## **RESPONSE TO SUBMISSIONS - EASTLAKES SHOPPING CENTRE MOD 1**

This letter has been prepared by Urbis on behalf of Stateland East Unit Trust (The Applicant) regarding MP09\_0146 Mod 1 – Modification to Eastlakes Shopping Centre Mixed Use Development. The Modification was placed on public exhibition from 8 August – 23 August 2017 and submissions were received from the community, local and state agencies.

1 ELEVATION North (Gardeners Road)
1:200

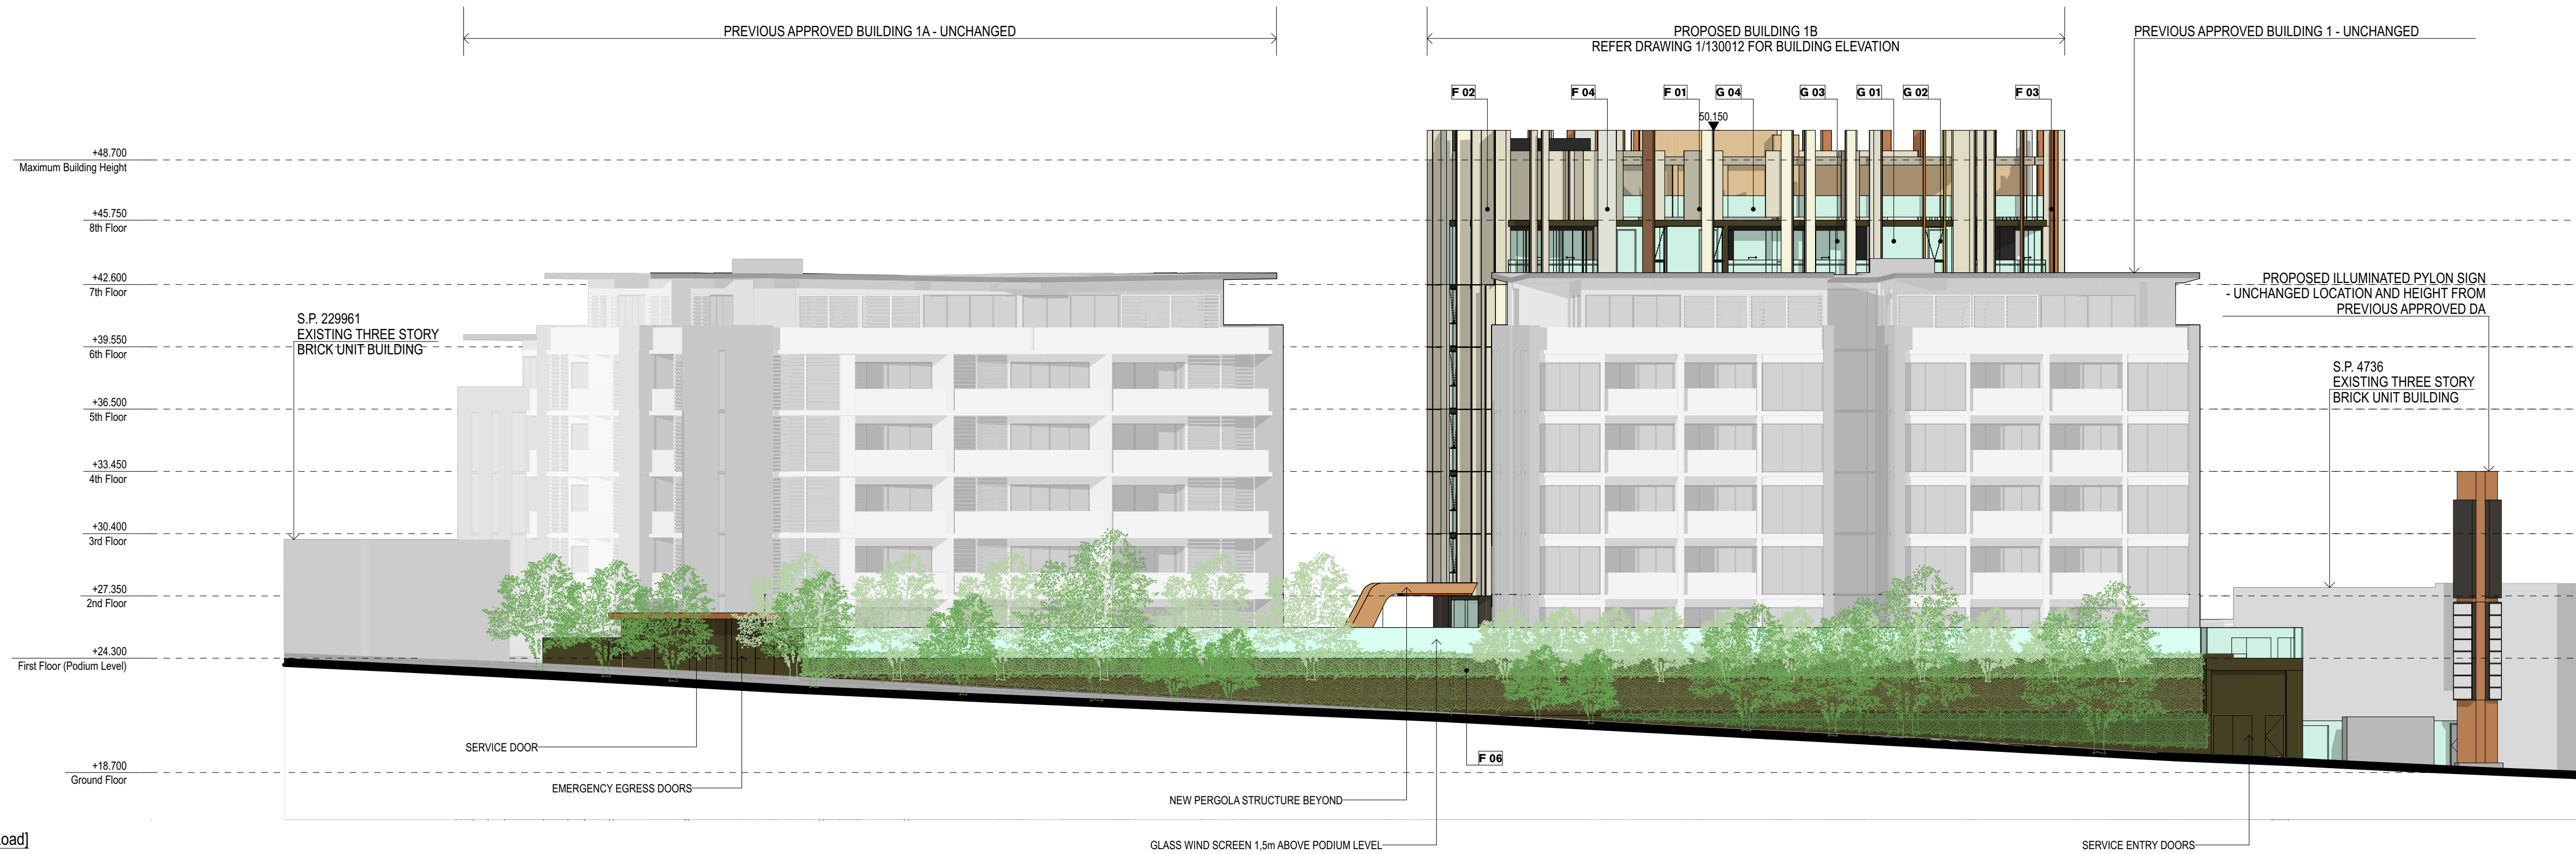
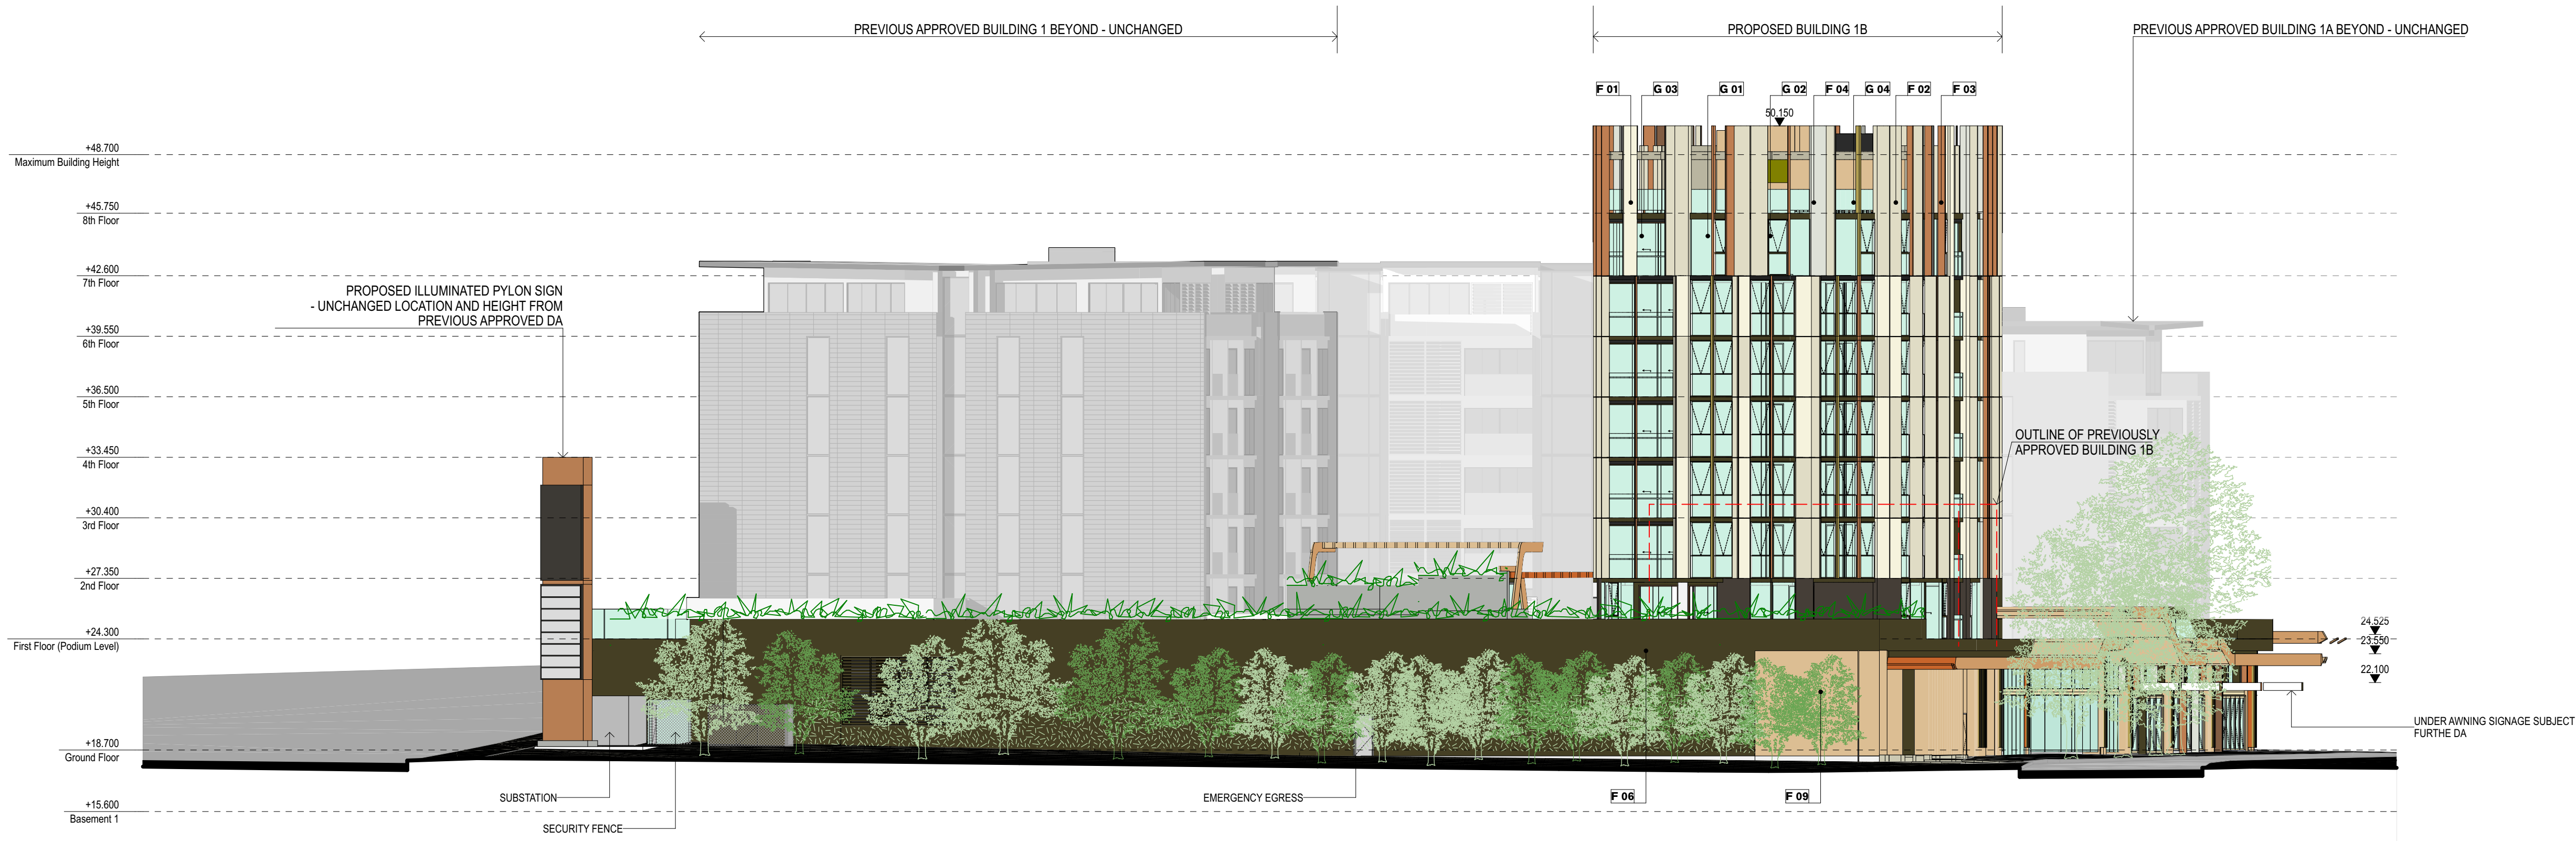
It is now sought to reinstate the signage zone along Gardeners Road. It is considered that Gardeners Road is a suitable location for signage and the proposed amendments sought by this modification to landscaping along this frontage enables it to be visible from the roadway.

The proposal also includes minor changes to the proposed landscaping along Gardeners Road. The revised landscaping scheme along Gardeners Road is illustrated on the elevation drawings prepared by FJMT and submitted at **Appendix A**.
